RE: WALGREENS @ 4TH ST & GRIEGOS NW

ENGINEERS CERTIFICATION FOR CERTIFICATE OF OCCUPANCY

Re: Walgreen's 4<sup>th</sup> and Griegos Grading & Drainage Plan, Engineer's stamp dated 7-01-02

Based on the information provided in your submittal dated July 1, 2002, City of Albuquerque Hydrology approves the above referenced plan for:

ENGINEER'S SEAL RONALD R. BOHANNAN P.E. #7868	WALGREENS 4TH AND GRIEGOS GRADING AND DRAINAGE PLAN TERRA WEST, LLC 8509 JEFFERSON NE ALBUQUERQUE, NEW MEXICO 87113 (505)858-3100	DRAWN BY BMP DATE 8/13/02 2221GR2.DWG SHEET # 3 JOB # 220021
---	--	--

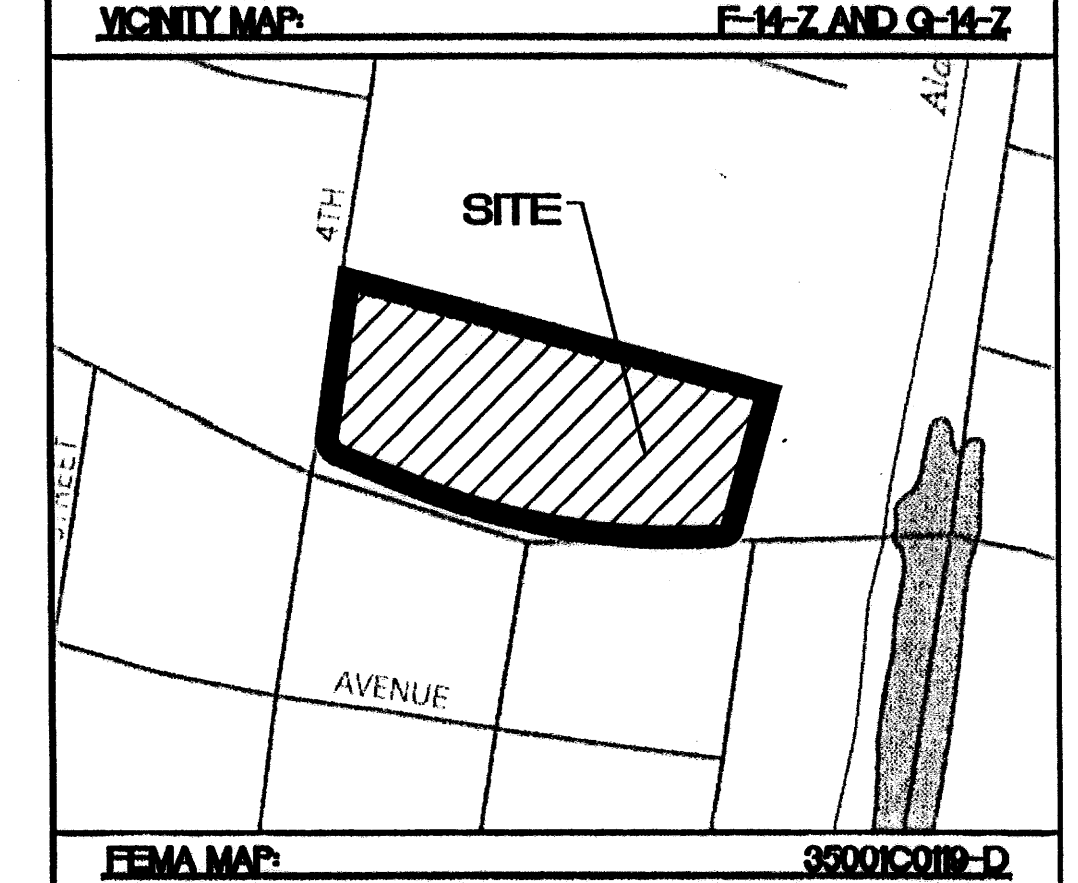
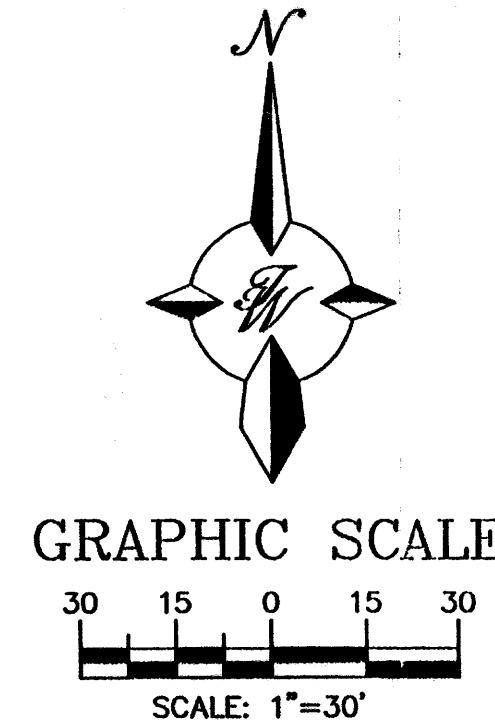
Your plan specifies in the Notice to Contractors, that the "contractor must contact line locating service, 765-1234 for location of existing utilities." Please note that this is no longer the point of contact; instead it is New Mexico One Call System at 260-1990.
